MCDONALD'S AT FONTAINE AND MARKSHEFFEL CONSTRUCTION DOCUMENTS VILLAGE AT LORSON RANCH FILING NO.1 LOT 2

FINAL DRAINAGE REPORT for

**McDonald's at Fontaine and
Marksheffel
Village at Lorson Ranch
Filing No. 1, Lot 2
El Paso County, CO**

PCD File No. PPR2427

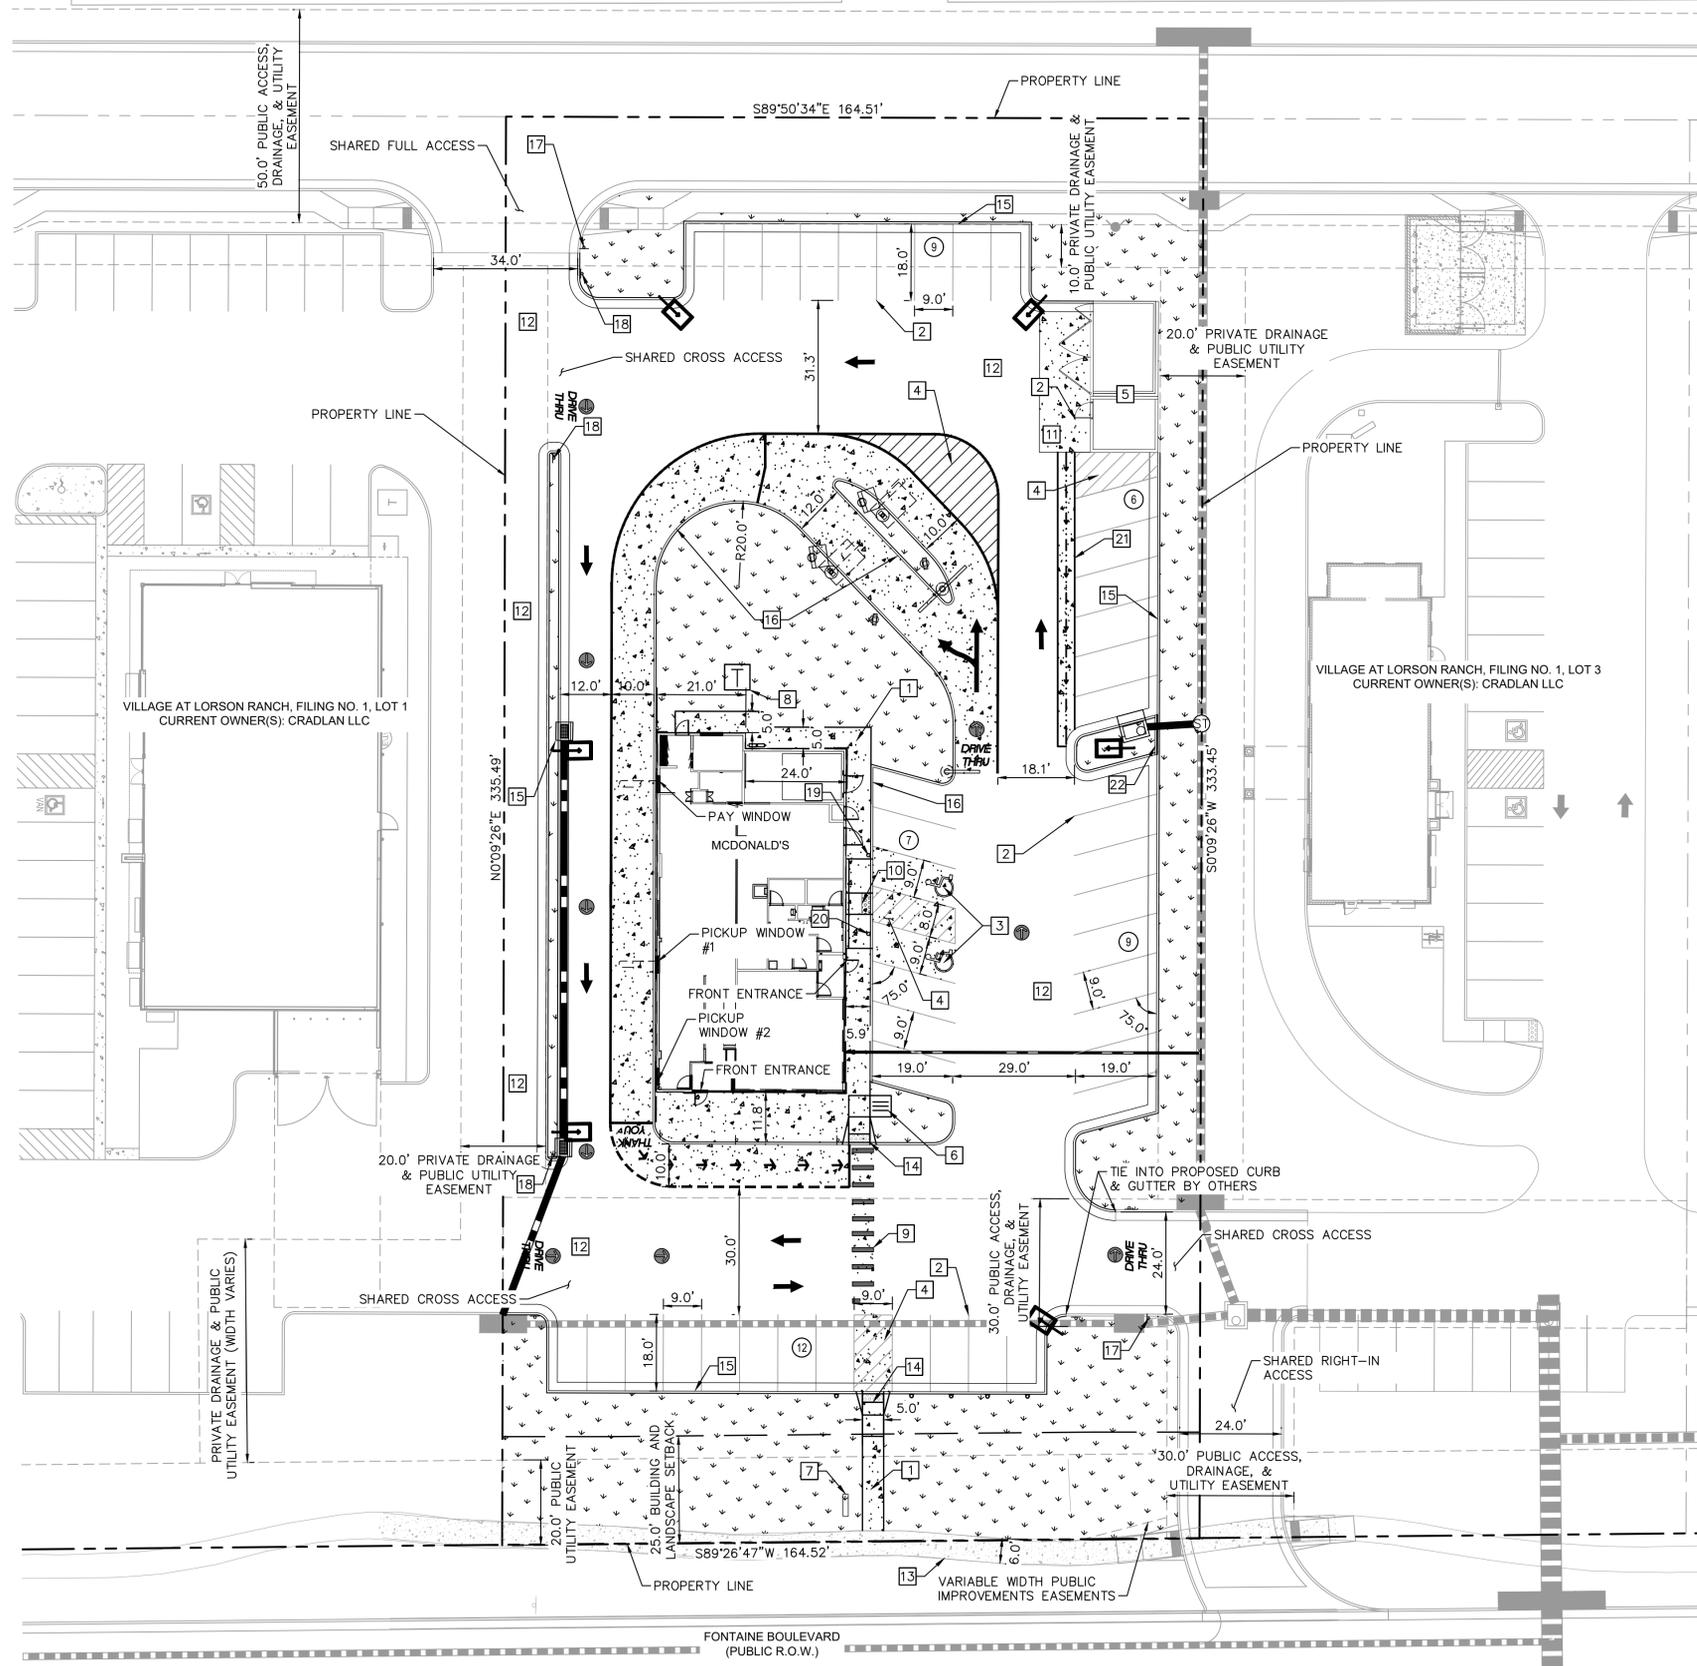
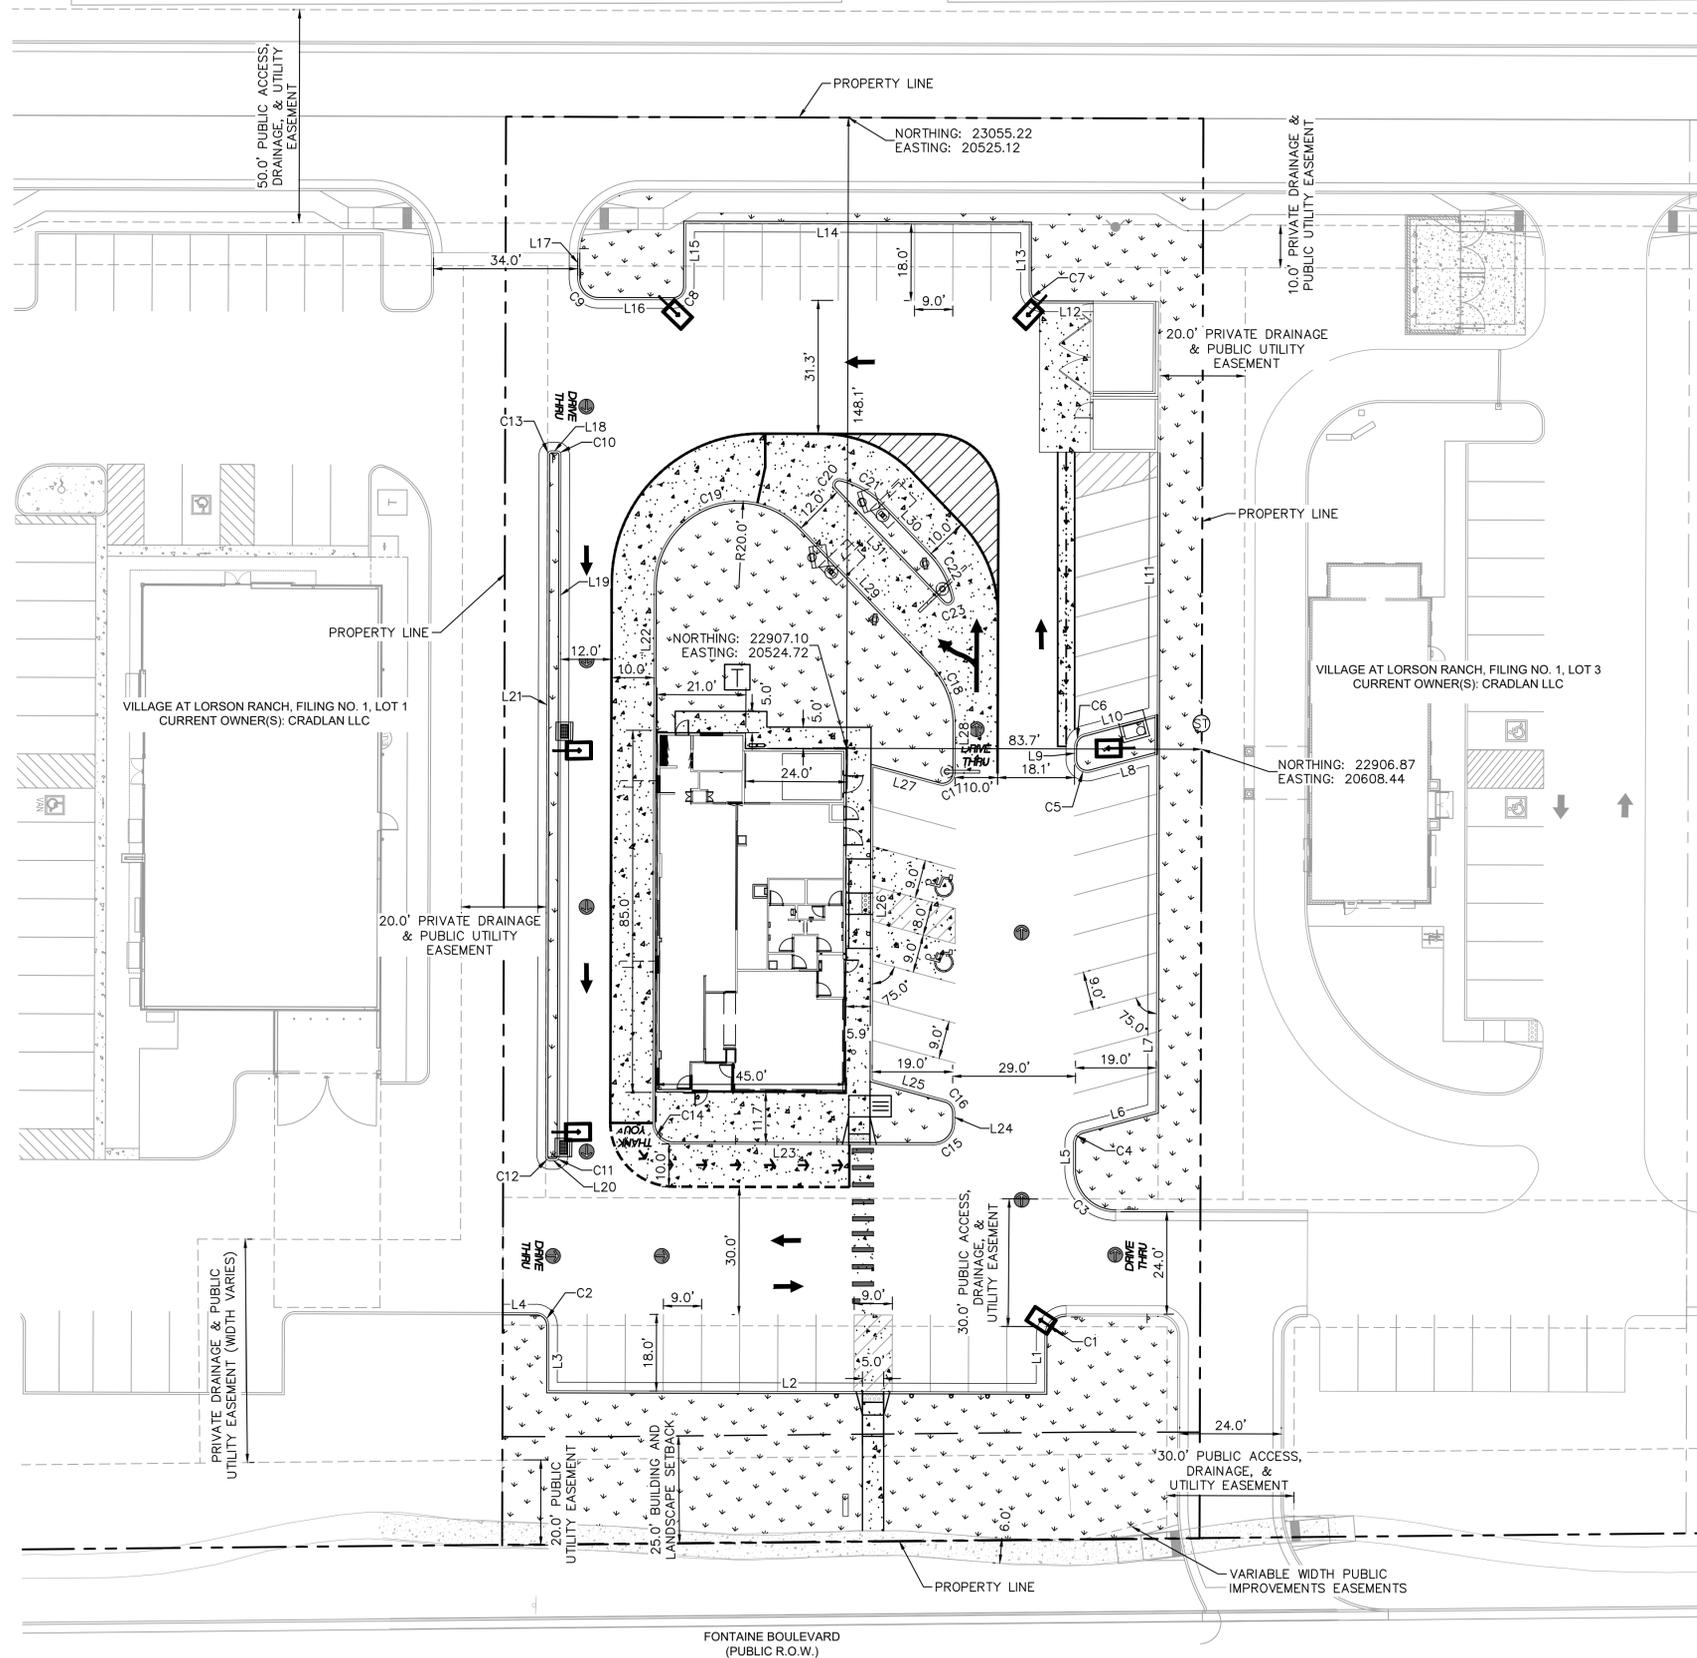
Please indicate asphalt paving in this area of the shared access. Asphalt should be included to the property line.
KH Response: Keynotes for proposed asphalt have been added along this property line.

Please show storm sewer on plan sheet
KH Response: Storm sewer has been added.

Please show storm sewer on plan sheet
KH Response: Storm sewer has been added.
